REQUEST

Current Zoning: B-D (CD) AIR (distributive business, conditional, airport noise overlay)
Proposed Zoning: I-1 (CD) AIR (light industrial, conditional, airport noise overlay)

Approximately 105 acres located between Shopton Road and Beam Road.

The petition proposes to permit the development of a vacant parcel with up to 1,250,000 square feet of gross floor area of warehousing, warehouse distribution, manufacturing, office, and industrial uses.

SITE PLAN

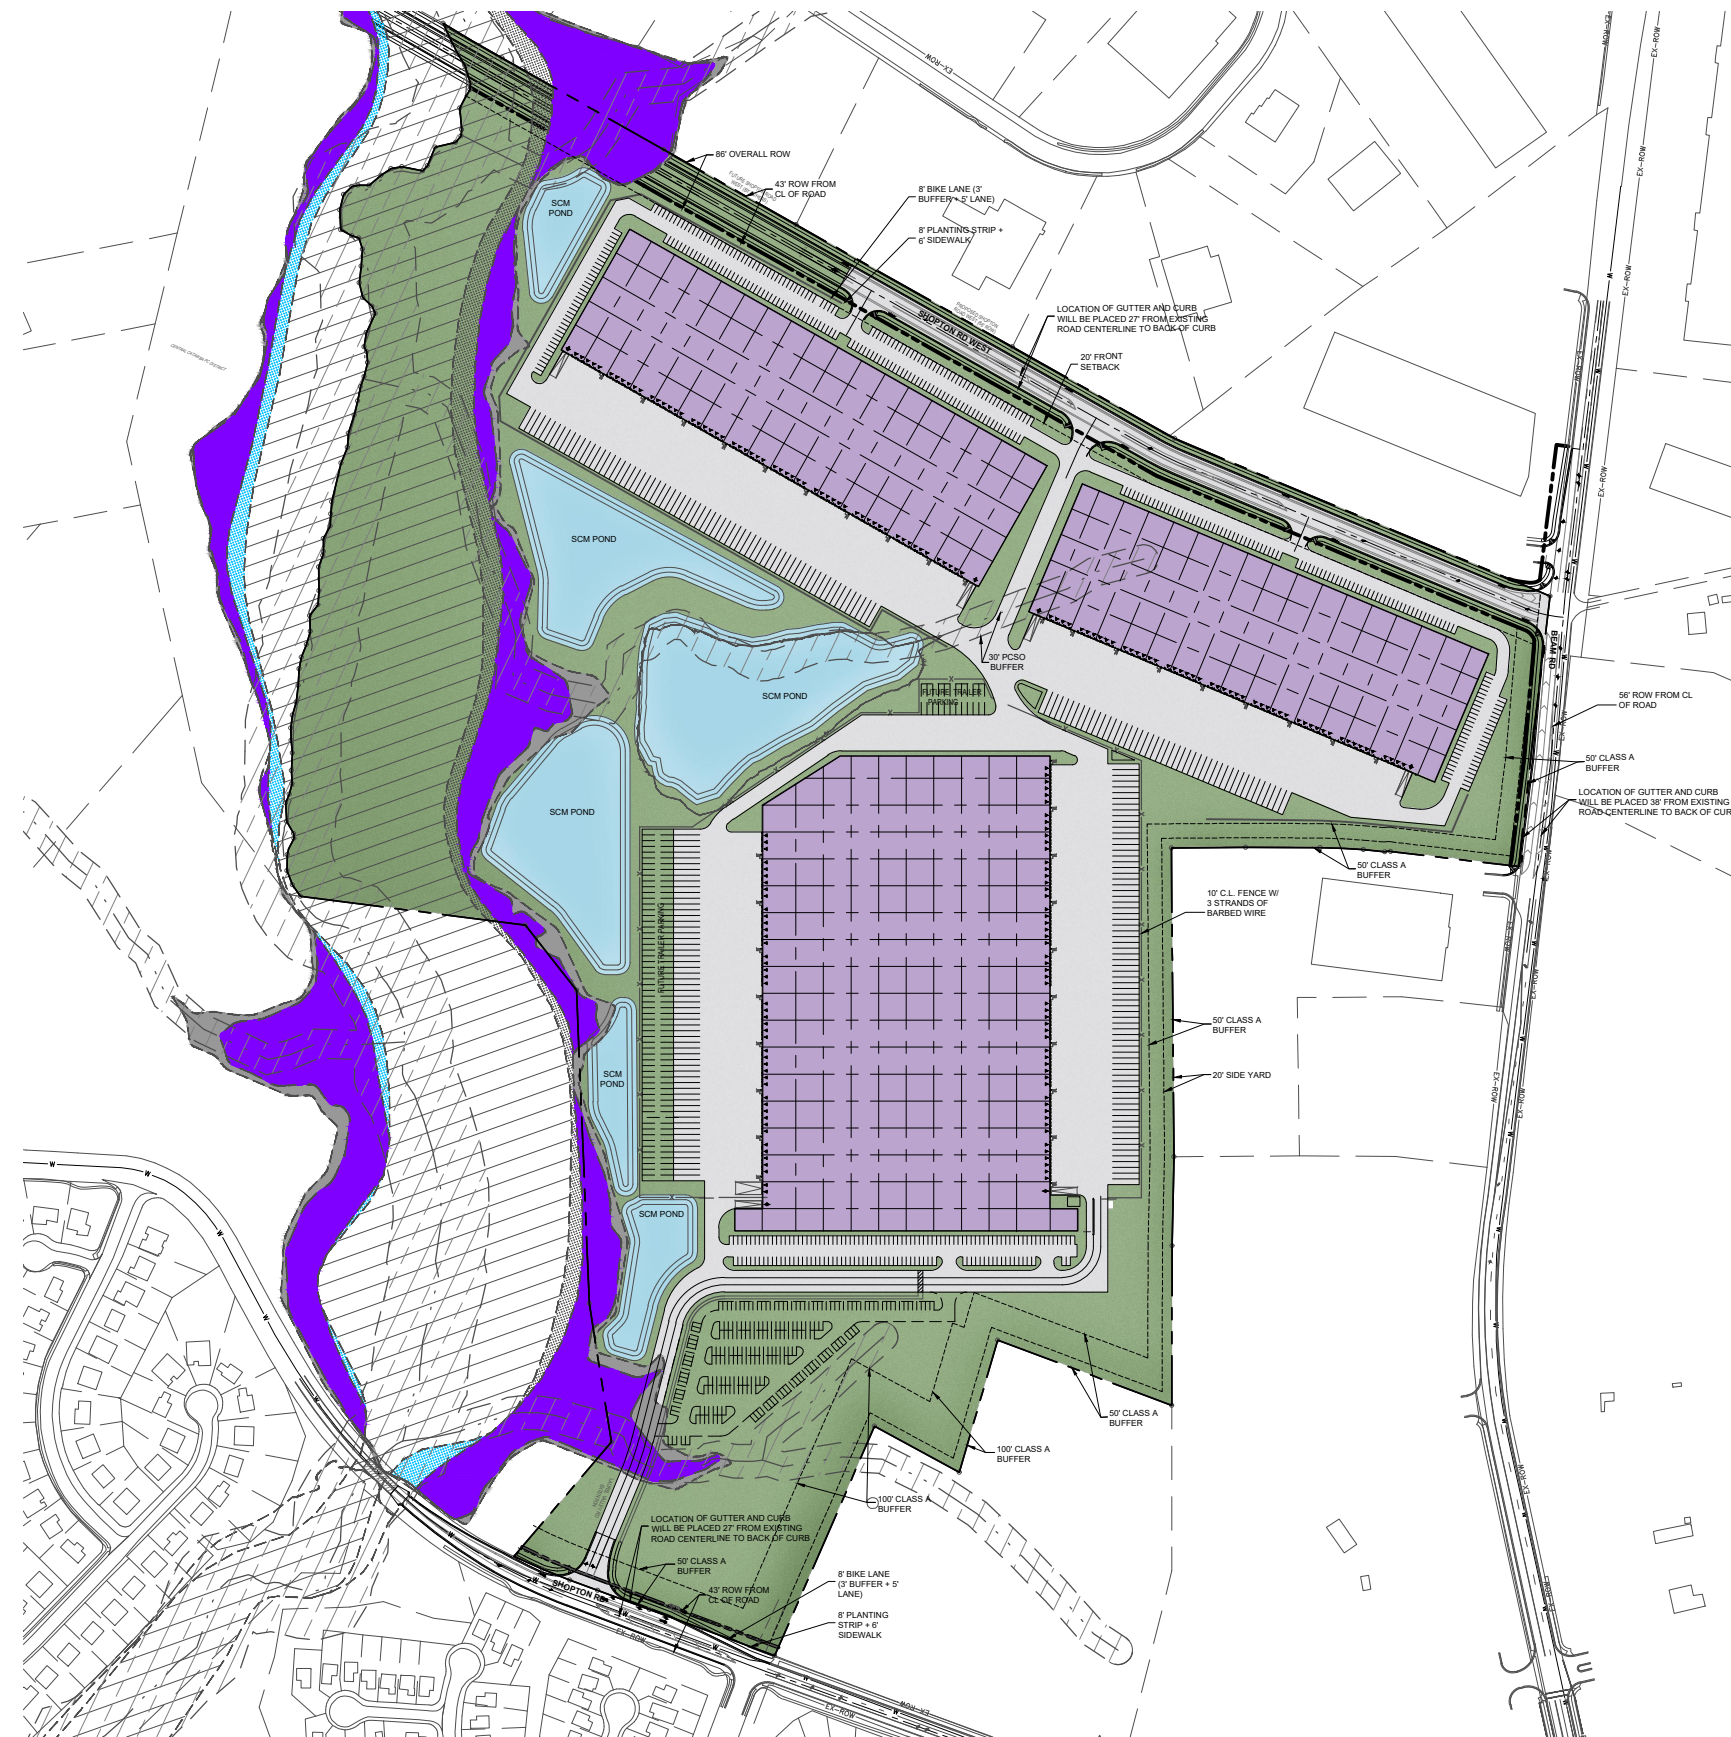
3. ~~Remove the "1/" from the building area square footage on site plan notes.~~ **ADDRESSED**
4. ~~Depict and label the buffer adjacent to Beam Road as 50' Class A. Correct corresponding note V.b.~~ **ADDRESSED**
5. Depict and label the buffers along the eastern and southeastern property boundaries as 100' Class A. Correct corresponding note V.a. **OUTSTANDING**
